From: Dan Young
Sent: Wednesday, February 26, 2025 9:40 AM
To: Ellie Myers
Subject: RE: AU-25-00004 Wetzel - Notice of Application

FM Comments:

Subject: AU-25-00004 Wetzel - Notice of Application

Please review the following Boundary Line Adjustment: AU-25-00004 Wetzel. Any comments need to be received by **5 PM on March 5th, 2025**.

Kevin & Laurel
Wetzel
Parcel # 799436
330 Cattail Rd.
Ellensburg, WA 98926

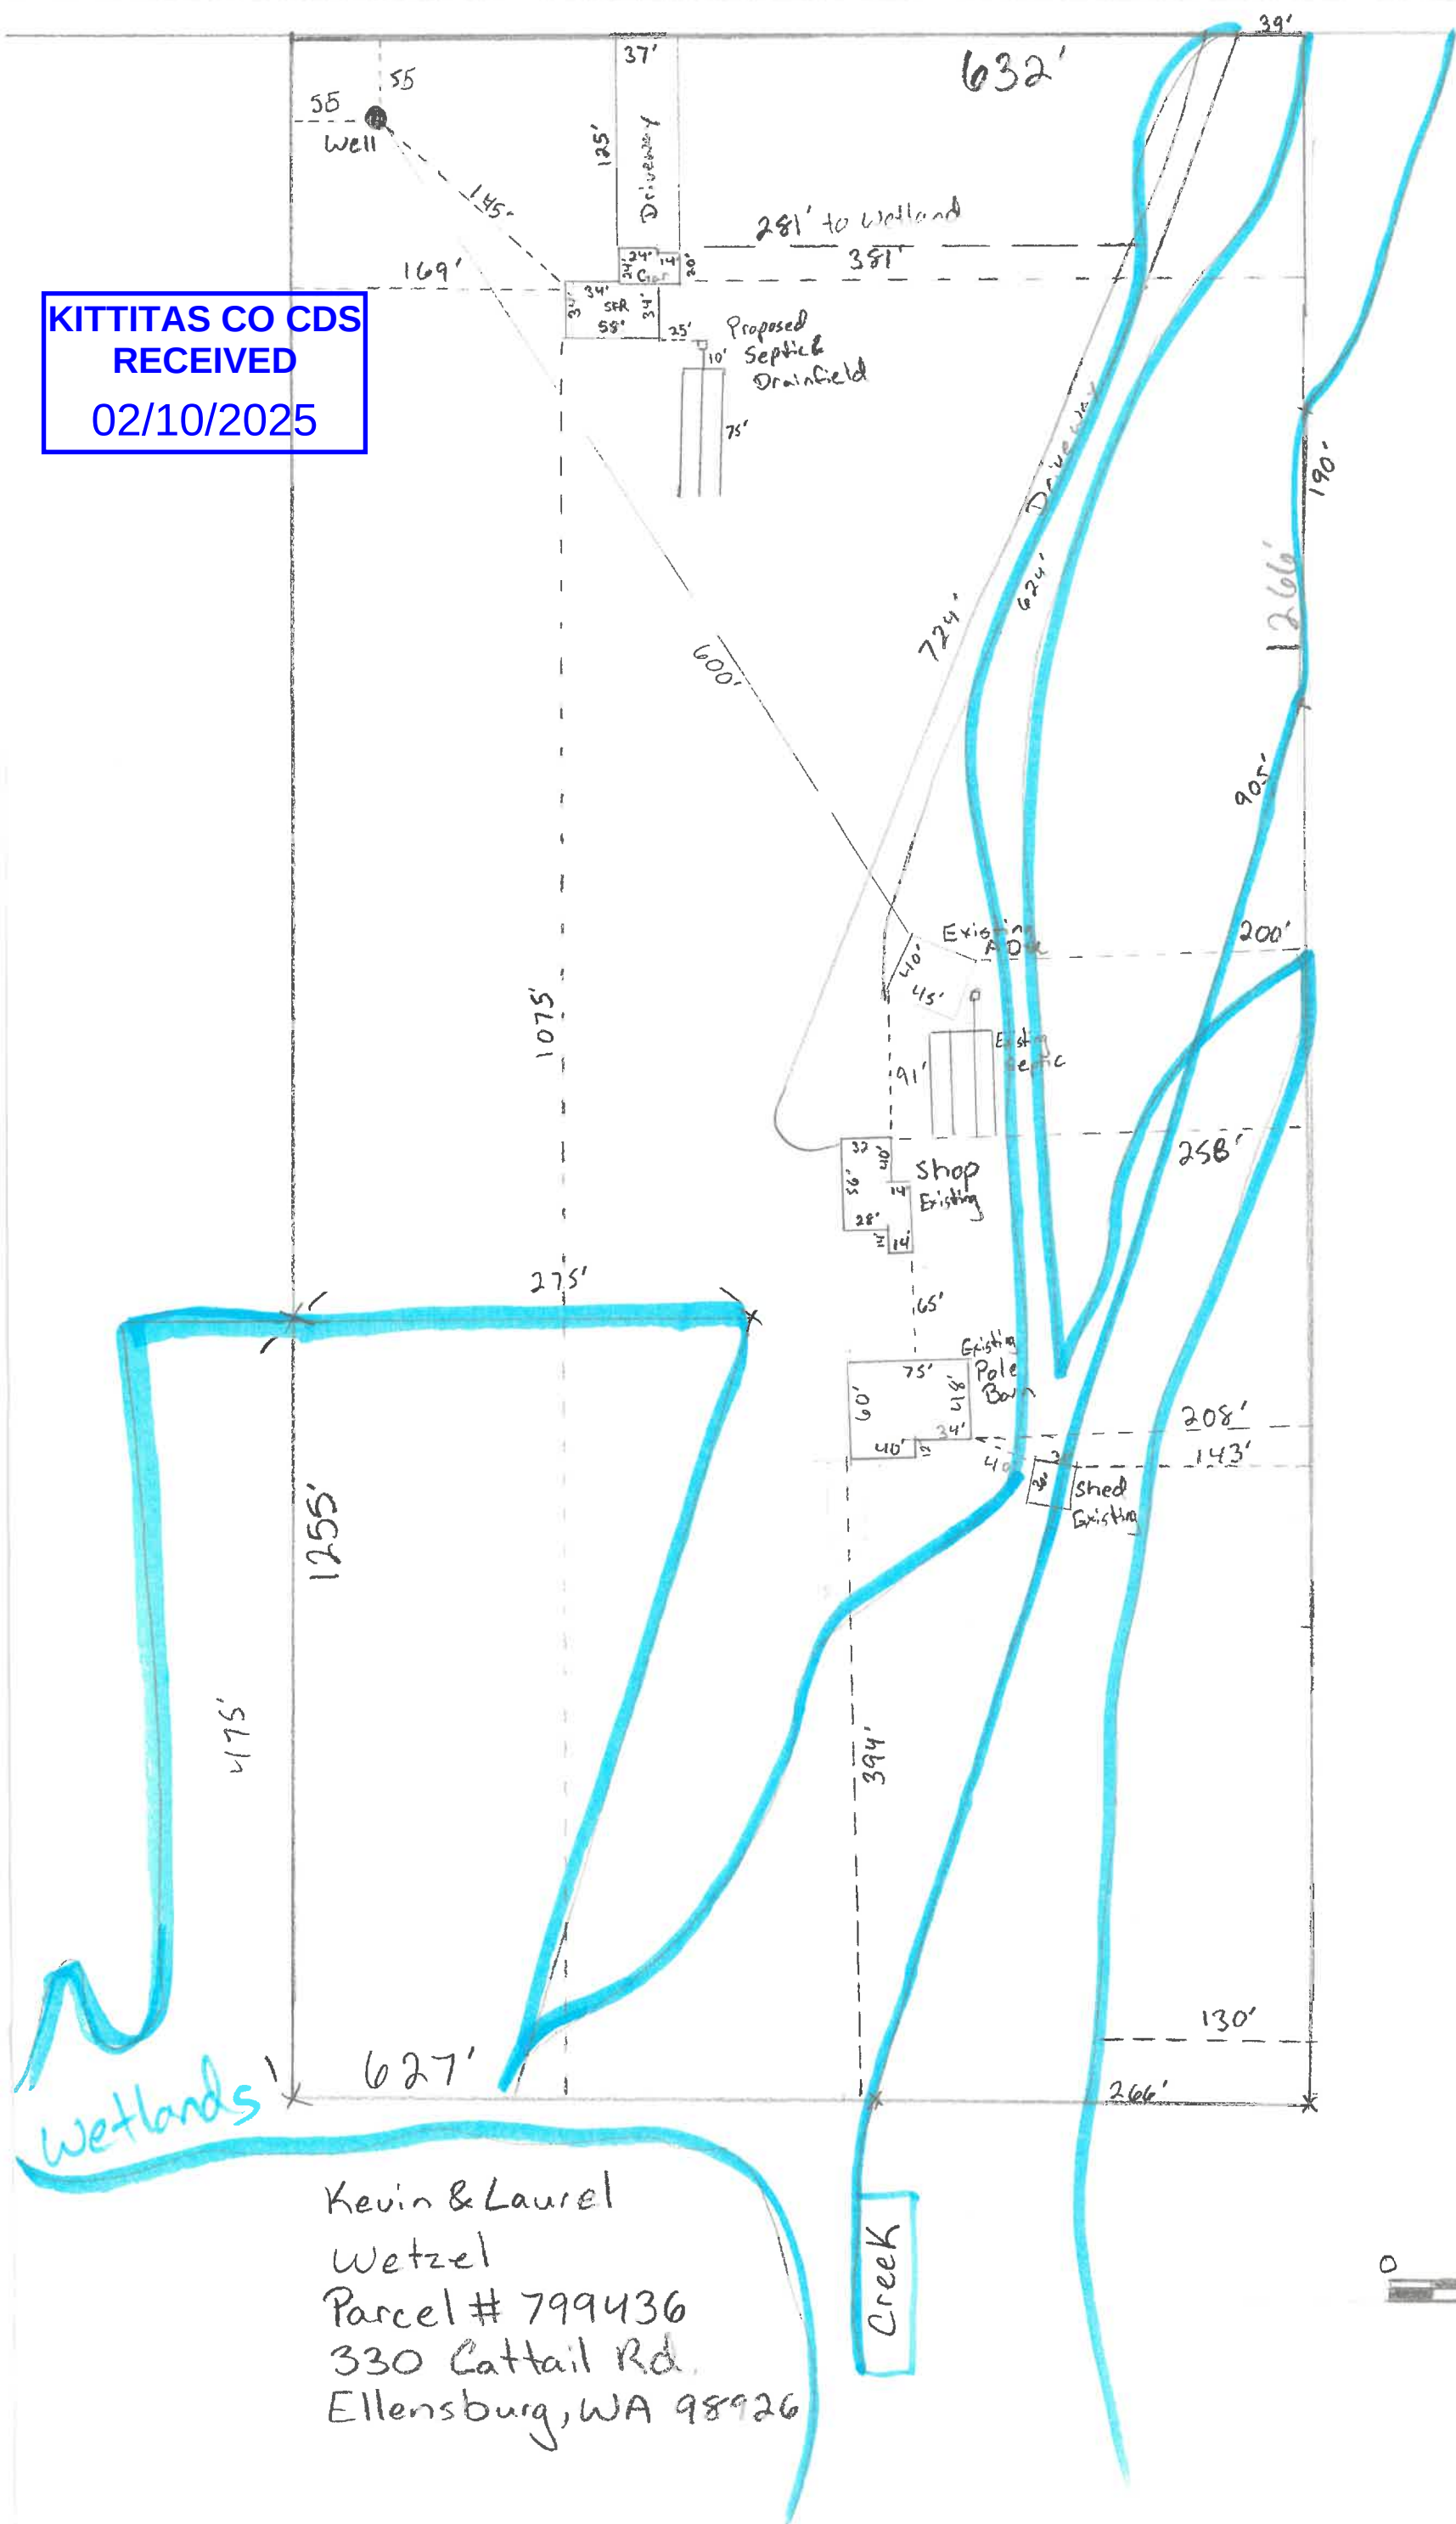
Driveways over 150 feet must have an approved fire apparatus turnaround. The indicated provisions for turning around fire apparatus are not adequate. Provide a turnaround meeting the requirements of the International Fire Code Appendix D.
